Drafted 28 June 2011

**Planning Applications, Ribble Valley District
D3-11-0404 Unit 5b, Salthill Industrial Estate, Lincoln Way, Clitheroe**

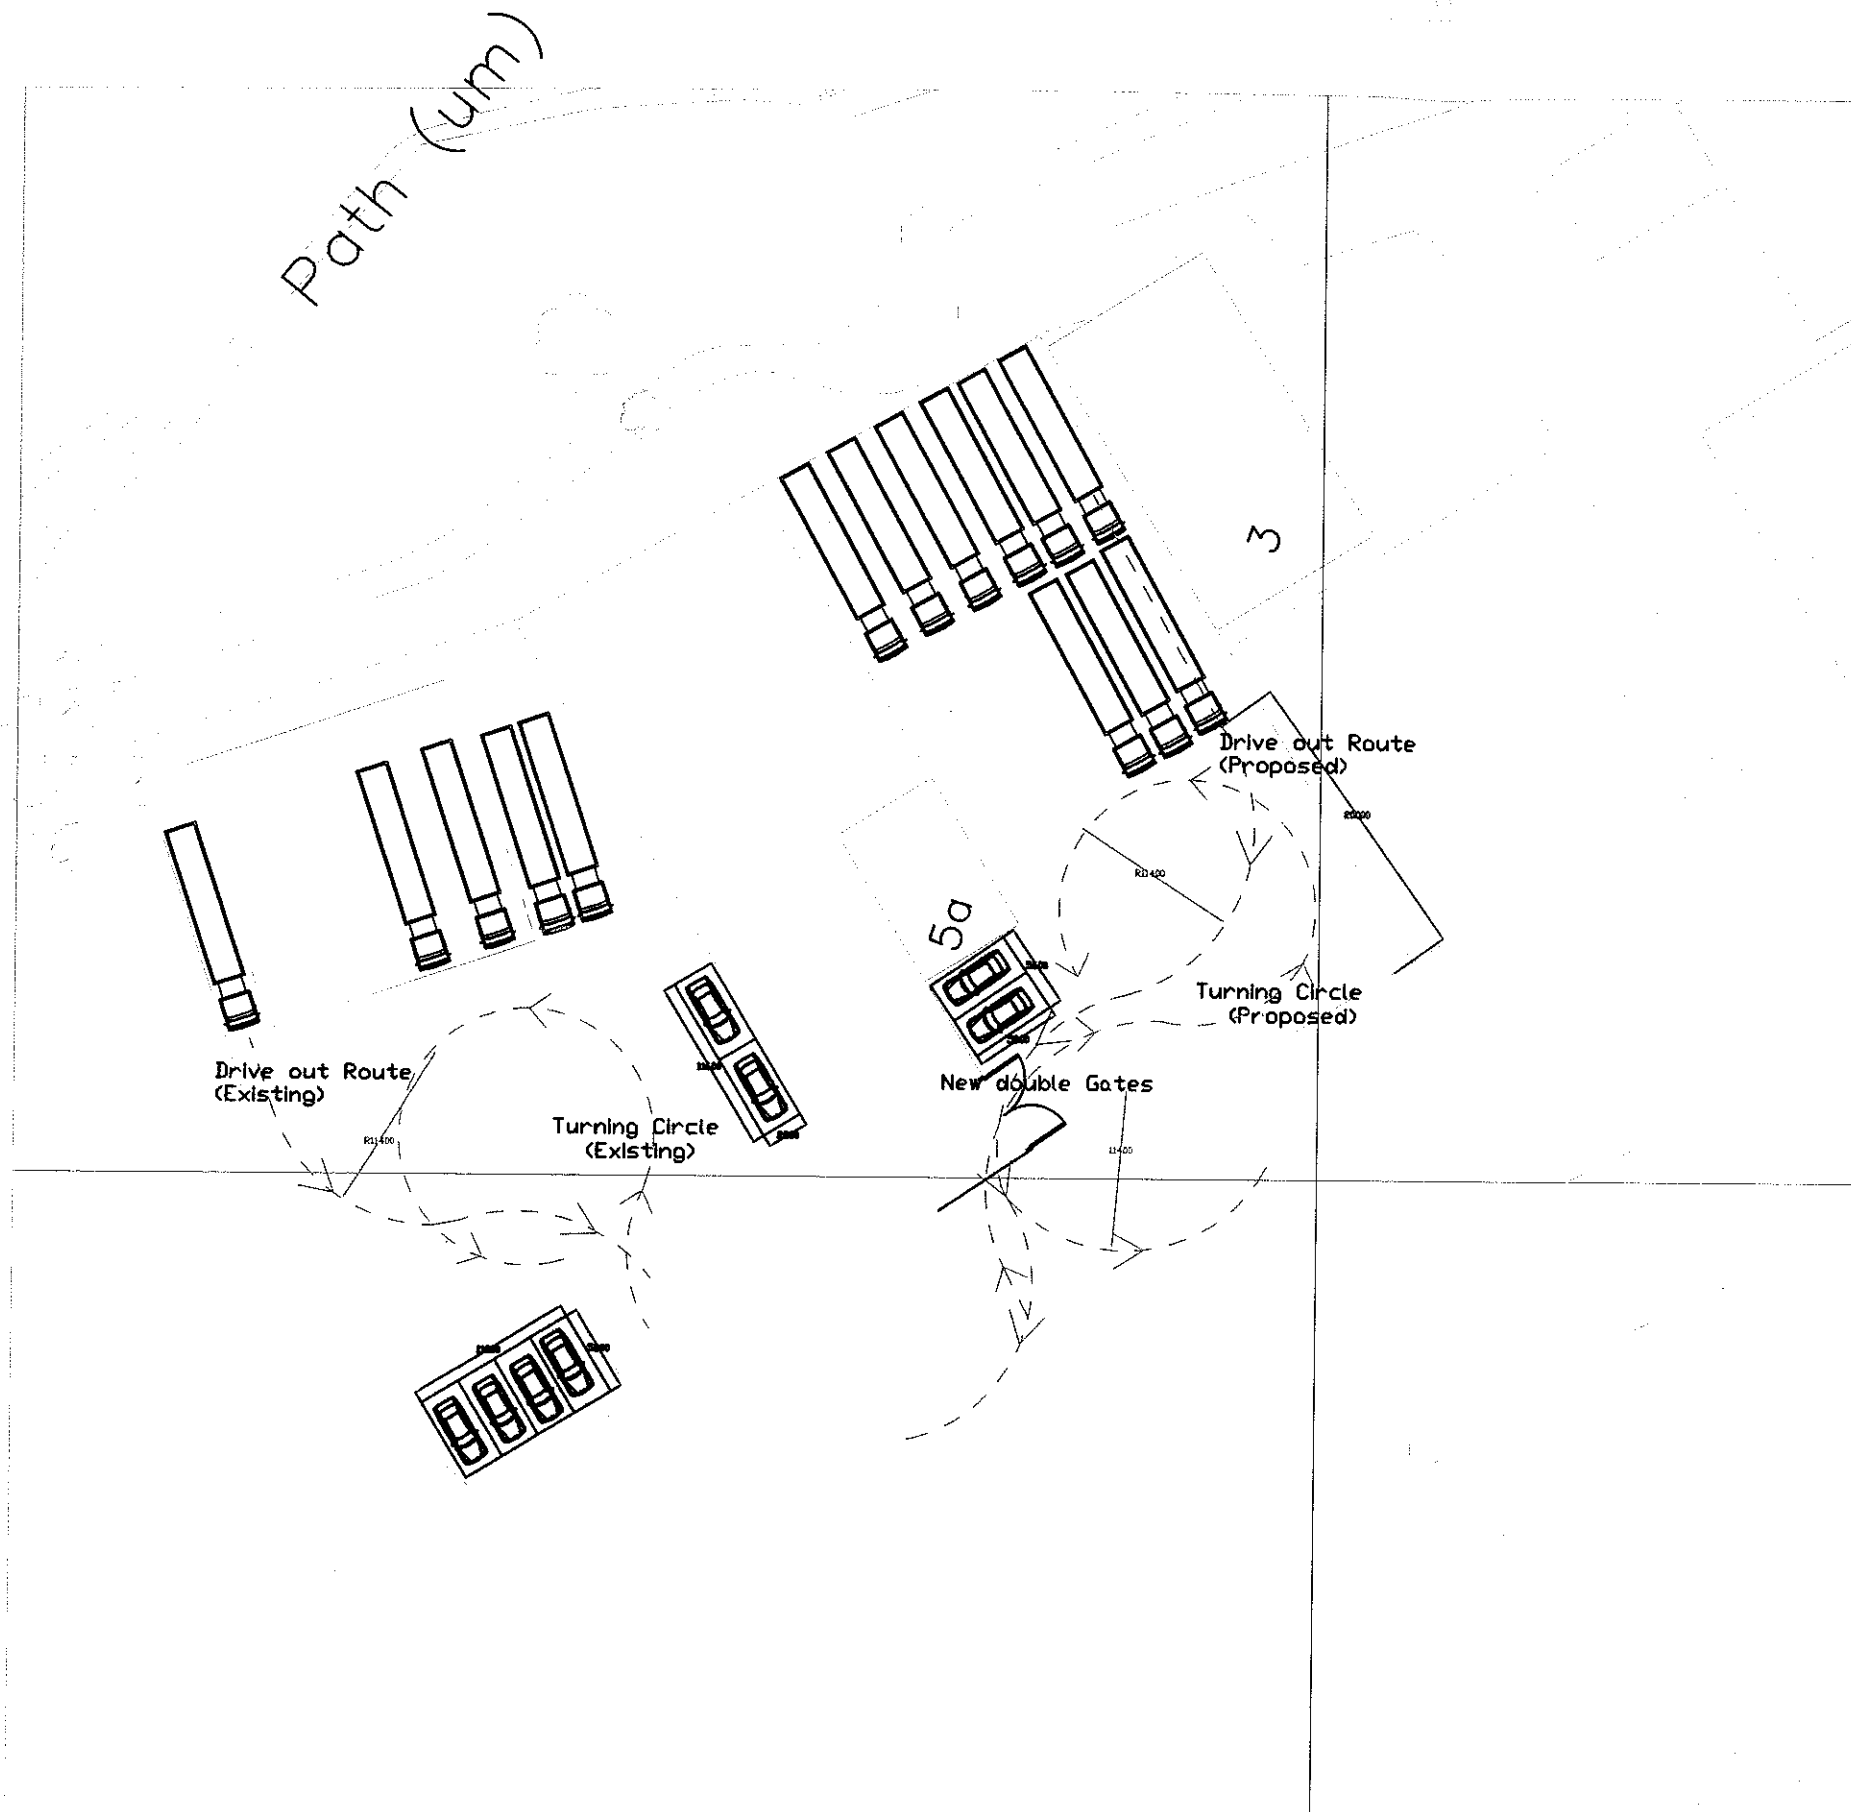
The application aims to accommodate 9 larger vehicles and parking for 8 staff vehicles within the development site. The plan provided in support of the application indicates parking for the larger vehicles within the available curtilage but does not identify the manoeuvring space required to achieve this parking arrangement.

In order to operate safely from this location it is imperative that all vehicles utilizing the site can enter and exit in a forward gear and the site shall be laid out so that all appropriate movements can be accommodated. The necessary parking provisions and the agreed vehicular turning spaces must be laid out and available for use before the development is brought into use. This is a necessary requirement to insure that no vehicles are reversing to and from the highway where they could be a hazard to other road users.

In addition, the staff parking spaces must be shown on the site plan so that permanently marked spaces can be identified as part of any future consent and that the safe operation of the proposed layout can be assessed. The present plans do not give any indication of the location or operation of the staff parking area.

I would welcome revised plans that aimed to address the above comments. These should include clearly defined areas of operation within the site and details of swept path analysis to confirm that larger vehicles can enter and exit Unit 5b in a forward gear and manoeuvre safely within the site.
